From: Damian Sullivan
Sent: 28 August 2013 11:34
To: 'Simon Brodrick'
Subject: RE: R/152/13 8 West Mead, East Preston

Thank you for your e-mail. However, I also need an amended plan to drawing no. 15/13/2006 not showing the proposed wall which can then supercede the existing plans. Please may I have this as a matter of urgency.

Obviously my client would like to negotiate some kind of front boundary screening at some time but given that this may have a bearing on the existing proposal I agree to withdrawing this element of the plans which is shown on drawing no 15/13/06 - 03 and leave only the extensions to the dwelling and the garage.

PROJECT Proposed front and rear extensions including extension to garage with pitched roof and new raised front wall at 8 West Mead, East Preston. BN16 2SL	Scales 1:50, 1:100 1:500, 1:1250	Revisions	
	Date May 2013		
	Drawn srb	Drawing No 15/13/06	3
CLIENT Mr & Mrs K Drew

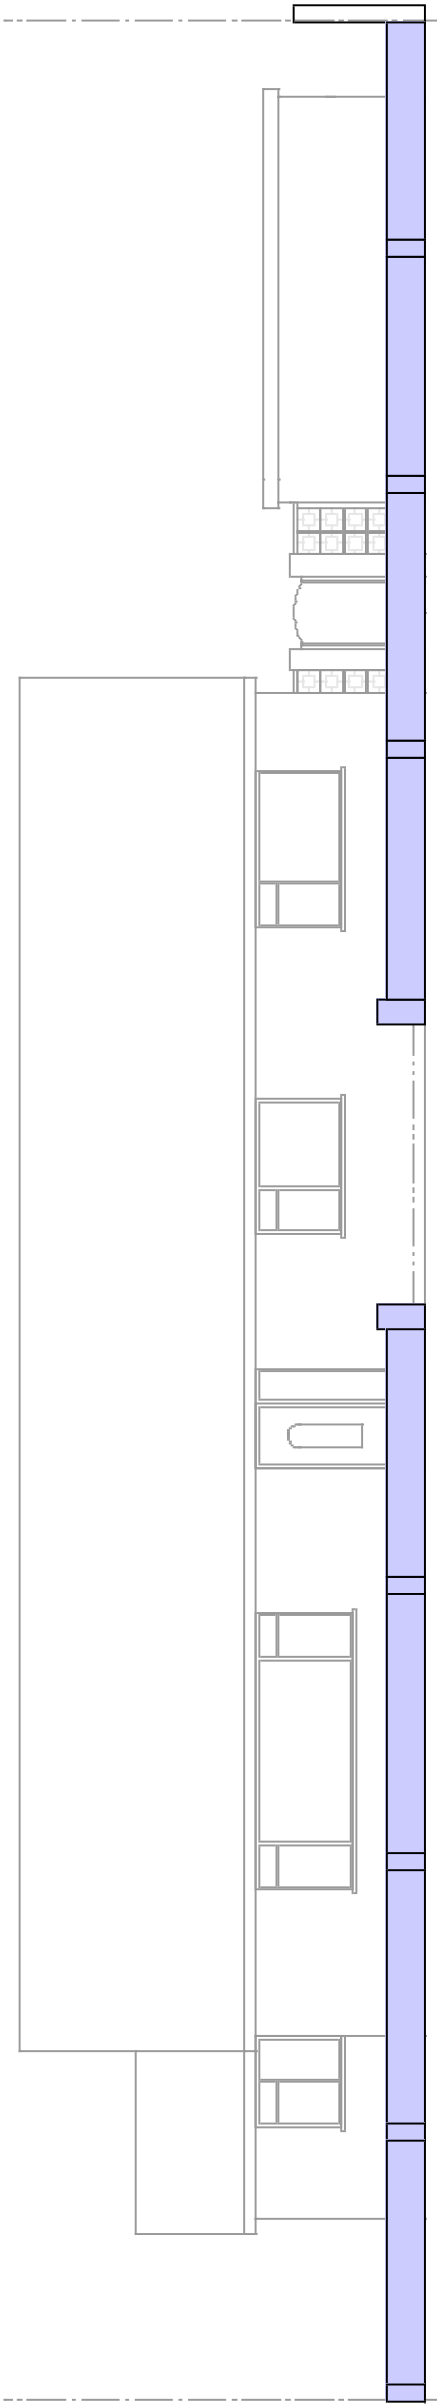
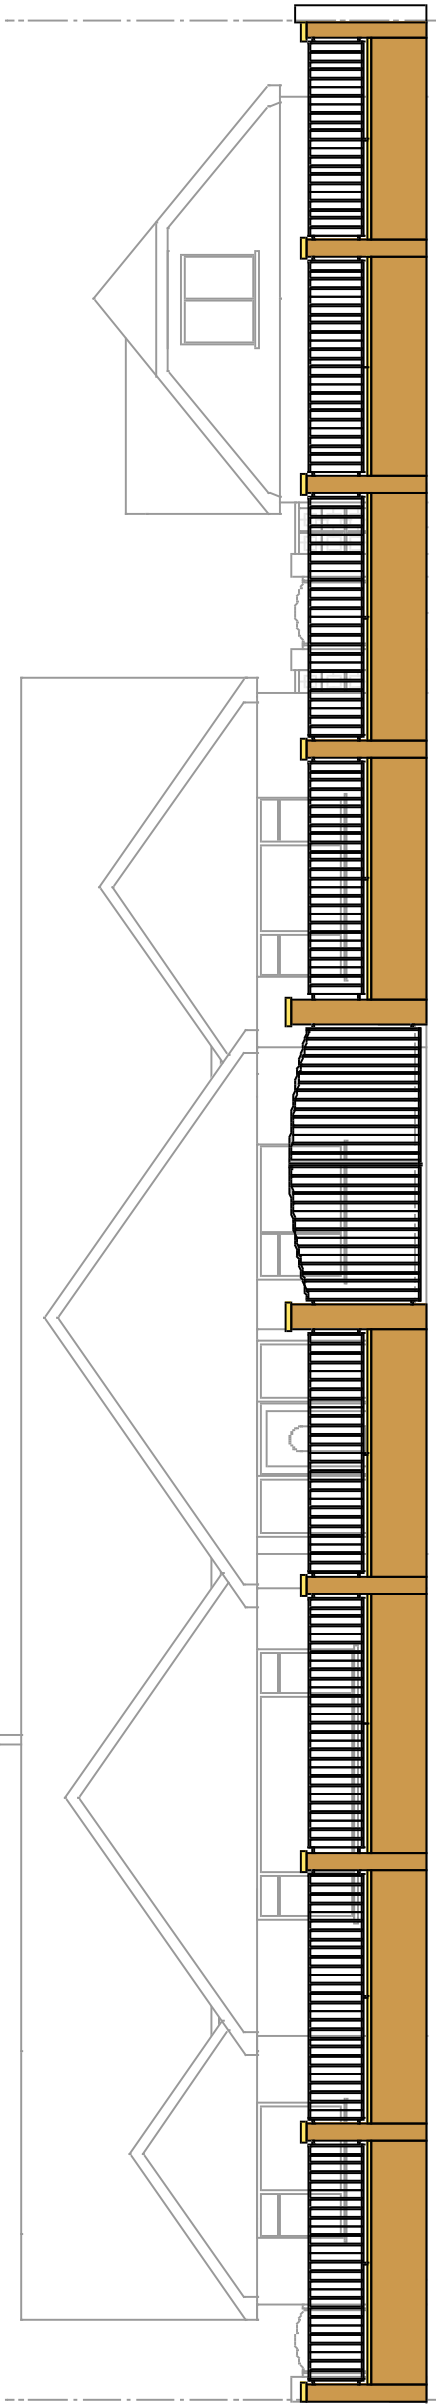
Further to our conversation last Friday, just a reminder about confirming the deletion of the front boundary wall at the above address and amended plan of drawing number 15/13/06 dated May 2013 at your first convenience.
